**Portland Fire Department**

RE: 276 BRACKETT ST  
PORTLAND, ME 04102

**NOTICE OF VIOLATION  
AND ORDER TO CORRECT**

# BUILDING SKETCH ADDENDUM

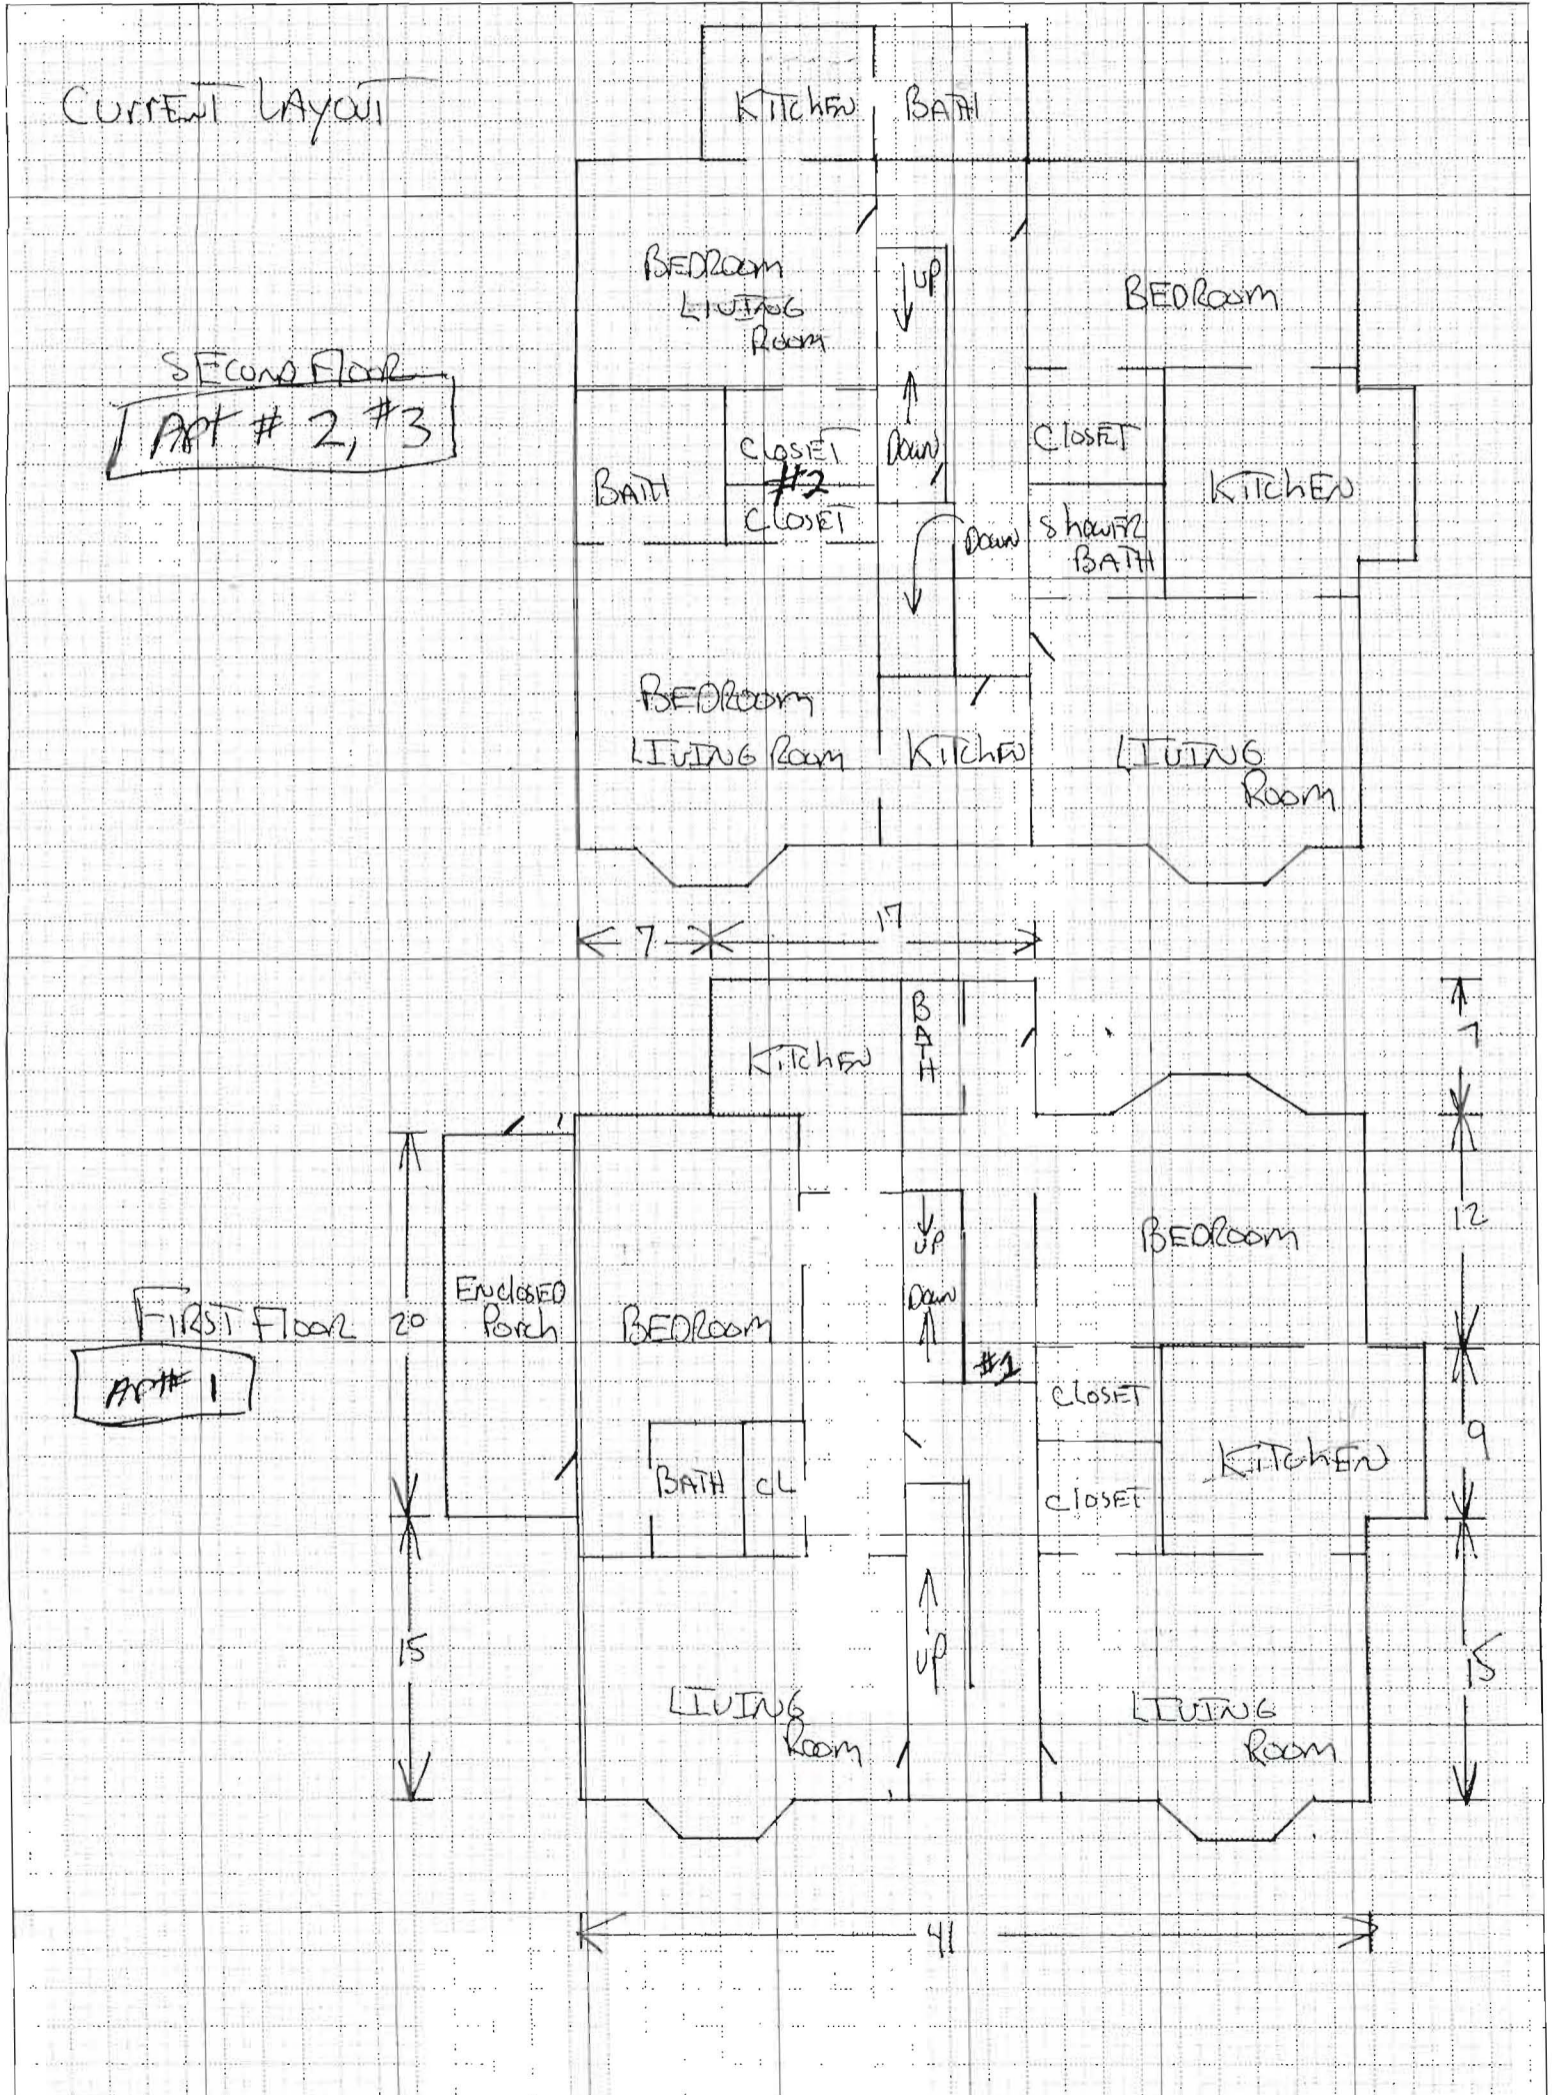
<b>NAME</b>	<b>CODE DESCRIPTION</b>	<b>COMMENTS</b>	<b>Deadline</b>
NFPA 101-8.6	Vertical openings shall be enclosed or protected in accordance with Section 8.6.	Bedroom in basement not separated from the boiler area,	7/19/2007
NFPA 101-Ch. 8	The fire barrier, including walls, ceilings, floors, etc. must be maintained with the minimum required fire rating.	Hole above basement door	8/11/2007
NFPA 101-31.2.2.1	1-hour fire rated doors and assemblies required, including self-closing and self-latching mechanisms.	Need fire doors, basement and 1st floor	10/10/2007
